AENC-NG-CNS-REP-0248

Norwich to Tilbury

Document: 8.3.32 Signed Statement of Common Ground -
Tritton Farming Partnership and Brett Aggregates (Lowleys
Farm Mineral Site) - Clean Version

Planning Inspectorate Reference: EN020027

Figure 1 Adopted Scenario B of the Project in the vicinity of Lowleys Farm

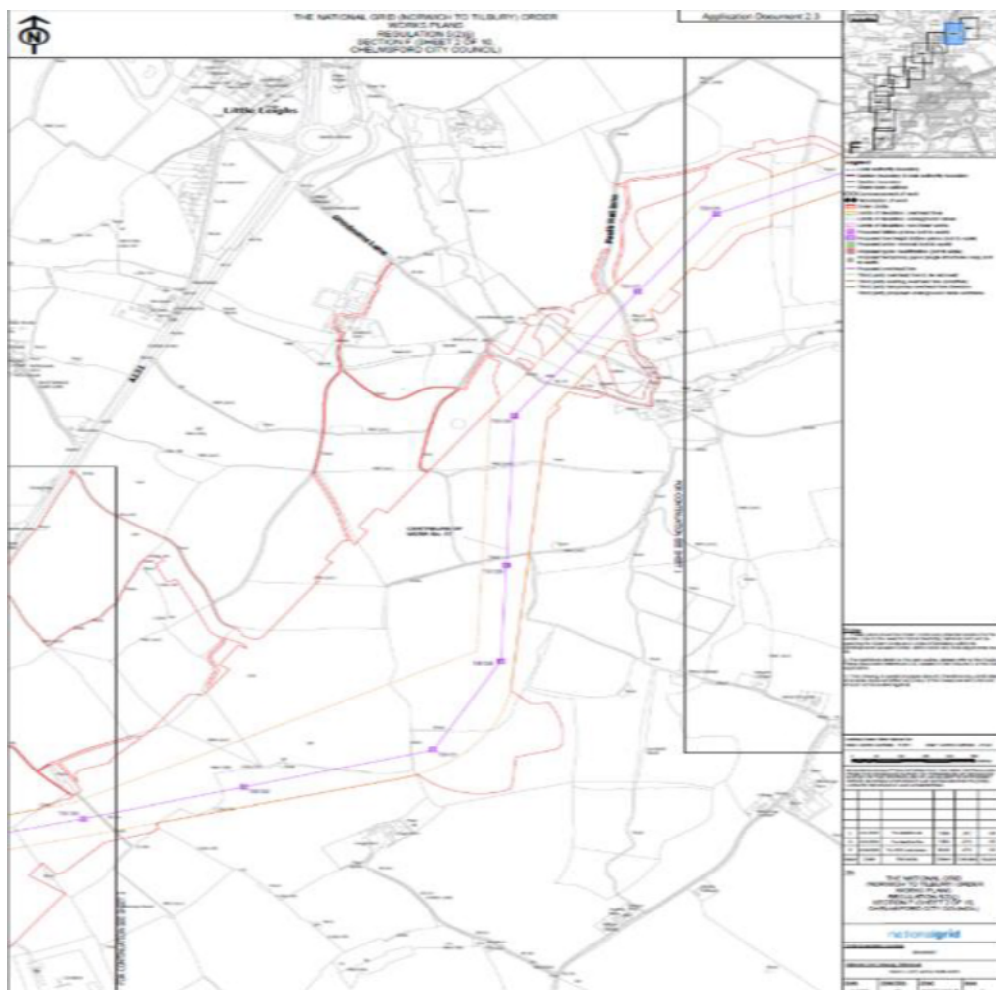
SoCG ID	Summary of matter under discussion
9.1	The extent to which the adopted Scenario B alignment, tower position, tower heights and conductor sag may affect the proposed housing development, and whether further mitigation can reduce sterilisation once the detailed design is confirmed.

SoCG ID	Summary of matter under discussion
9.2	The impact of Scenario B on minerals, woodland, farming and housing, including the extent of land required within the Order Limits, the extent of any Class 8 Reduction Area, the Applicant's proposed contractual undertaking regarding future land rights reductions, provision of detailed design information, and whether reductions in land ownership requirements and Order Limits should be secured before the close of examination.

ID	Issue	National Grid Position	TFP and Brett Position	Status
		permission is yet to be granted for the proposed housing development. Scenario B, as shown by Figure 1, would move the Project alignment further to the south-east within the Limits of Deviation to minimise the interaction with the minerals site. This was confirmed in 8.11 Approach to Scenarios [REP4-310] which was submitted at Deadline 4. The Applicant will continue to engage with TFP during detailed design, including provision of pylon heights and associated “sag”.	Change” and therefore we are working with the Applicant to continue to understand the detail surrounding the revised route and what flexibility there is to mitigate impact. We require TP130 to move as close as possible to the OHL Limits of deviation to the south. This may result in the removal of TP131 which will ensure sterilisation is kept to a minimum. 5.15 Design Development Report (APP-122), 9.1.3 on page 101 it states that <i>“Scenario B would require taller pylons and is unavoidably less direct, routeing around the edge of the anticipated minerals site while maintaining an appropriate stand-off from an area of ancient woodland.”</i> As Route B has been adopted, we would like the Applicant to confirm what the changes in size of the pylons will be to allow us to appraise its consequent impact. TFP proposes this matter is “ongoing discussion” as further details need to be presented and feedback provided to pylon locations and associated infrastructure within Route B to understand its impact to transition the working plans from “Preliminary and Subject to Change” to fixed.
